From: Jeff Smith <Jeffrey.Smith@endeavourenergy.com.au>
Sent: Thursday, 8 July 2021 9:30 AM
To: Grant Harlow
Subject: RE: S29/3/97-Mod-1 - Eastern Creek Karts, Departments design comments

Subject: S29/3/97-Mod-1 - Eastern Creek Karts, Departments design comments

Following on from our discussions on design requirements on 26th and 28th May 2021 for the above please see the following notes for design work :-

TITLE:		STATUS:	
SECTIONS		DEVELOPMENT APPLICATION	
DWG No:	SHEET:	ISSUE:	DATE:
LPS4.55 - 22/31	05	A	JULY 2021
SCALE:	DRAWN:	CHECKED:	
N/A	EW	RF

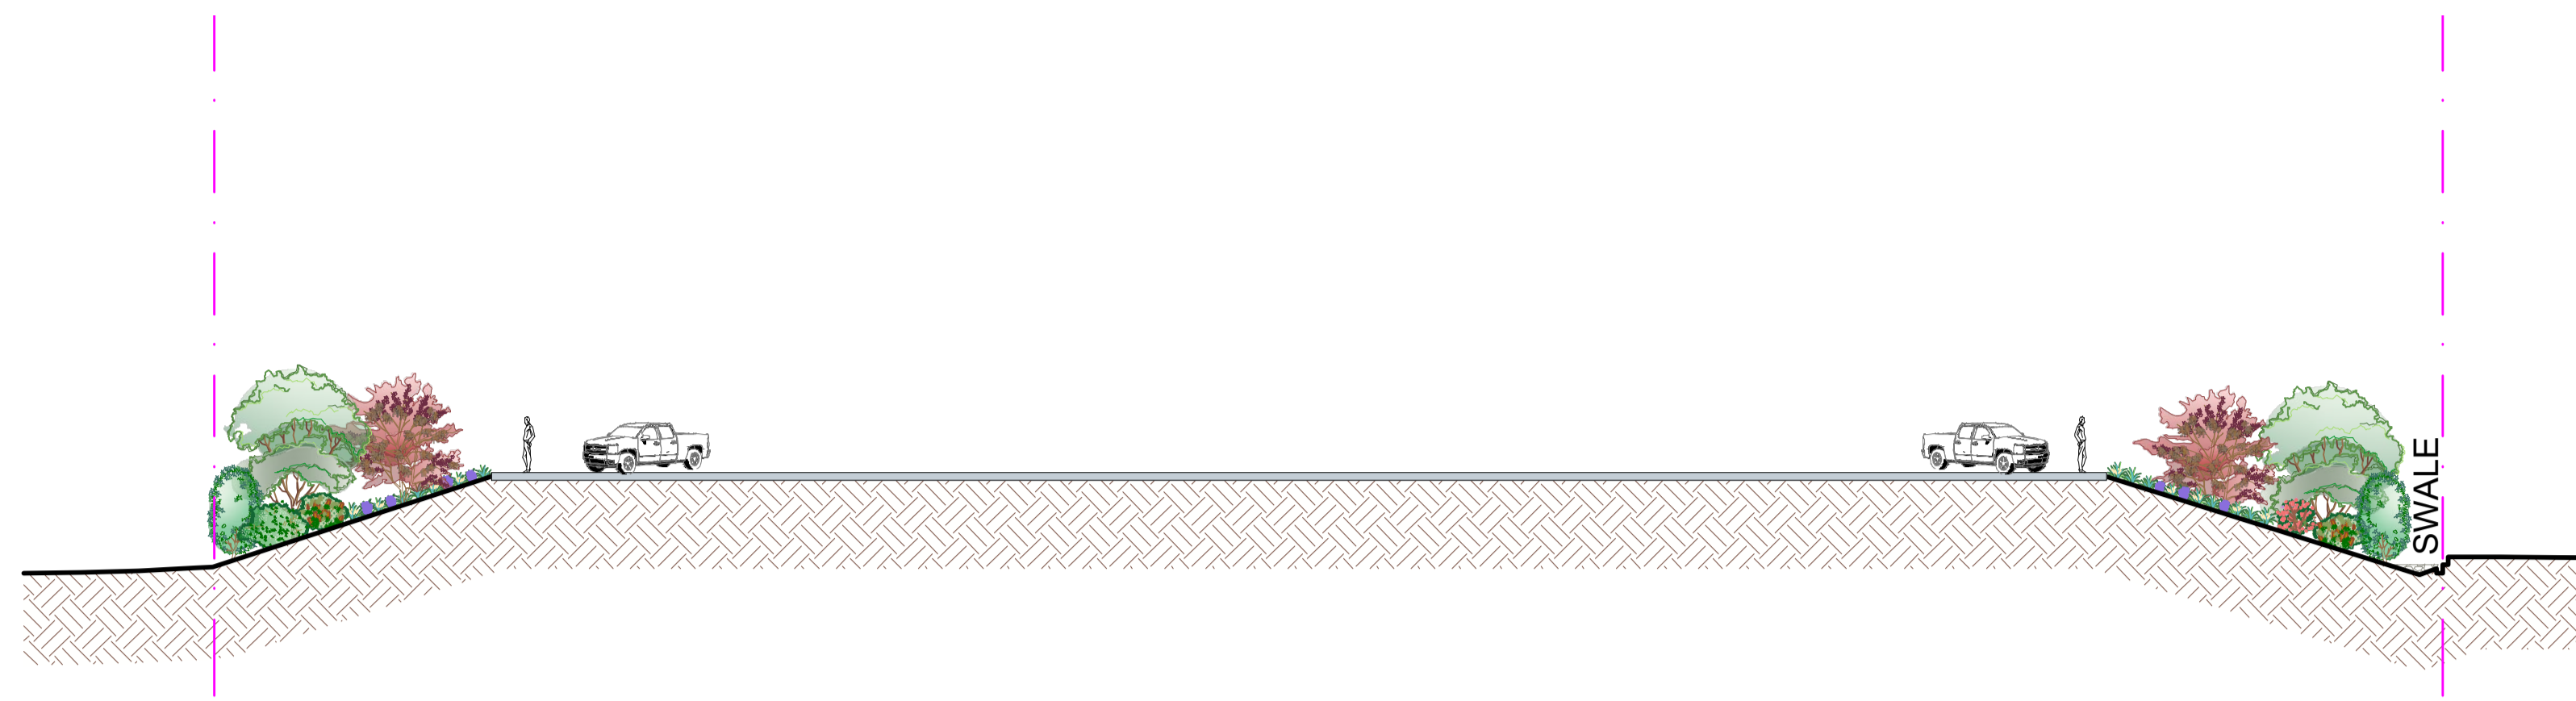
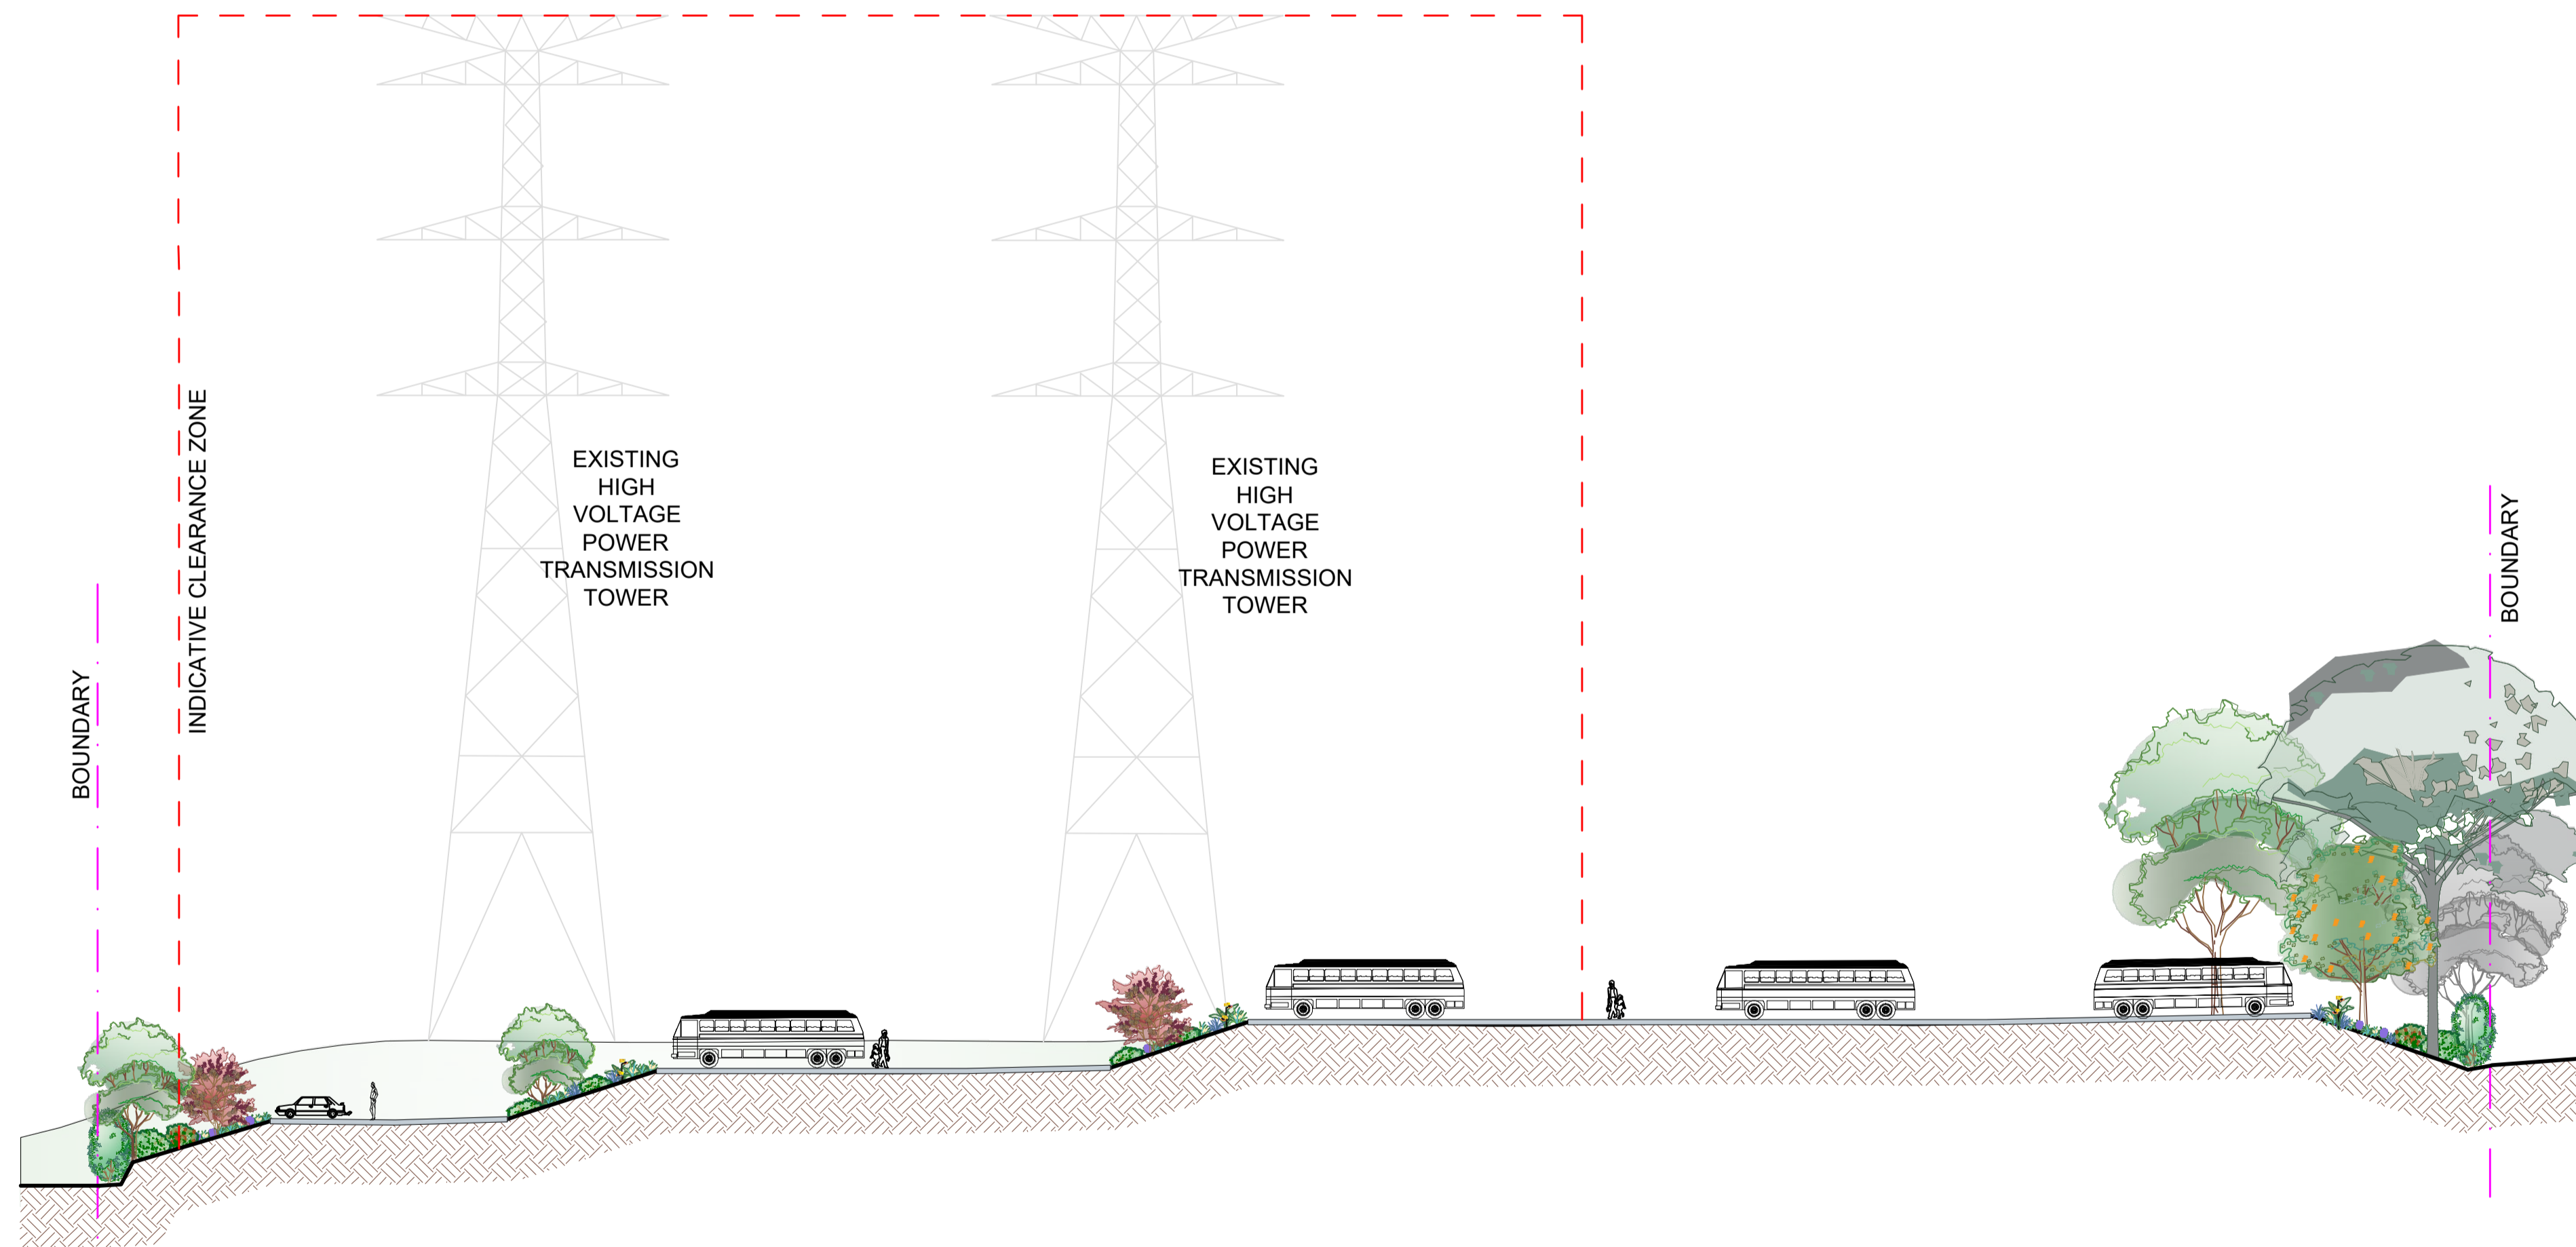
4. The height of the approach ramp adjacent the southern boundary sag point is lower than the height of the swale(s) or retaining adjacent 10 Raceway Close to direct upstream flows to the sag. A minimum 300 mm freeboard must be added to protective swales or retaining designed for this purpose.

9. Design matters in Dept. letter 13 May Sections 3, 4 and 5 appear not contentious.
10. Landscaping is emerging as necessary to reduce visual impact on the fill work, though subsequent to final drainage and carpark design. Allowance should be made for paving, kerbing and AS 2890 -compliant safety railing.
